KITTTITAS COUNTY COMMUNITY DEVELOPMENT SERVICES

March 29, 2021

RE: Salak Shoreline Exemption Application (SX-21-00001)

Site Address:	6322 Cove Road Ellensburg, WA
<b>SITE PLAN</b>	<b>Patrick &amp; Robin Salak</b> <b>17-18-07058-0001</b>
SCALE	1" = 40'
PAGE	<b>S</b>

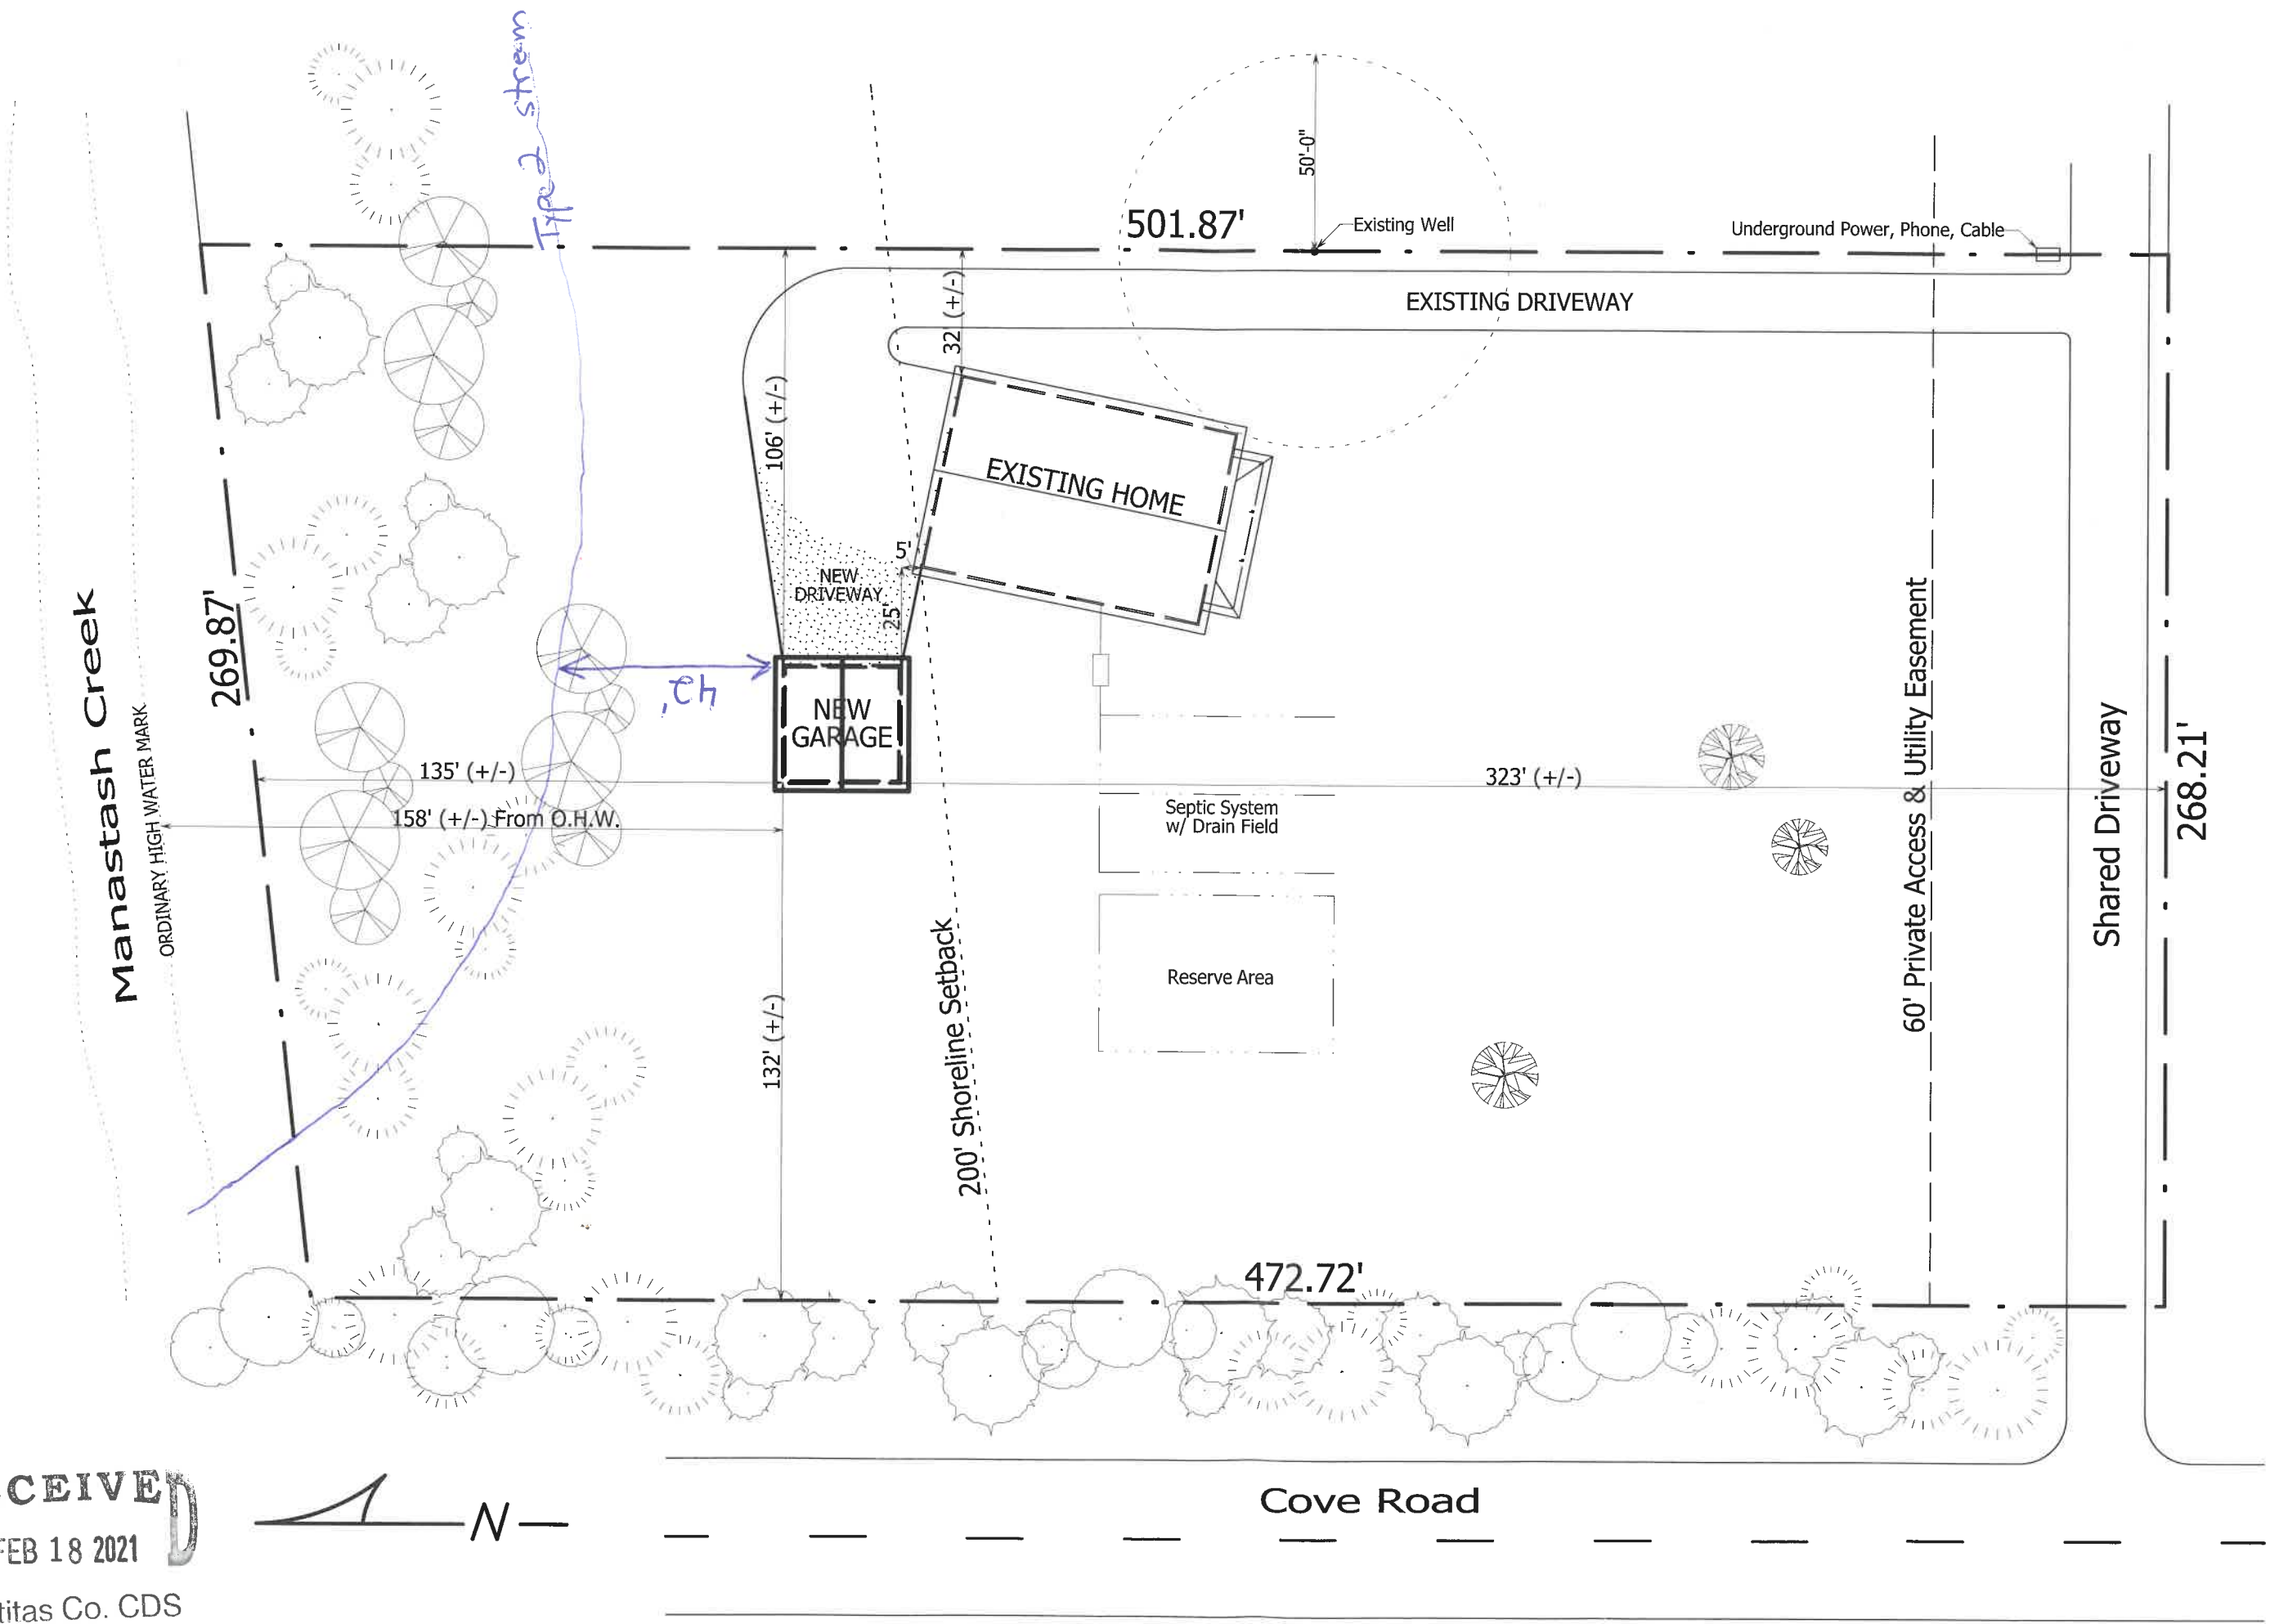
- 1) The Type 2 (Np) stream that serves as a tributary of the associated Shoreline Stream (Manastash Creek) requires a 50-foot structural setback in accordance with KCC17B.05.020K-1.
- 2) Kittitas County Code 17B.05.020B (3) General Regulations for Environmental Protection states: "... When reviewing proposals for new shoreline use and development, the Administrator shall first determine whether identified shoreline impacts have been avoided and secondly minimized."

"Public Works recommends denying the variance request. The proposed location is known to be at significant flood risk, as observed during the May 2009 flood event and historic flow channels located within 200 feet of the current Manastash Creek channel (and within 220 feet from Manastash Creek on the East edge of the property boundary). These flood risks can best be addressed by locating the structure outside the historic flow channels and south of the area that flooded in 2009, which will not occur if the variance request is approved."

Development of a detached garage on this lot will require a flood development permit and will need to comply with Kittitas County Code Chapter 14.08. Public Works staff is available for Technical Assistance."

The review of your proposal has found adequate land outside of the 200-foot shoreline jurisdiction that could be used to place the proposed new garage. This determination protects the state's shorelines, known significant flood risk areas, and your future proposed structures.
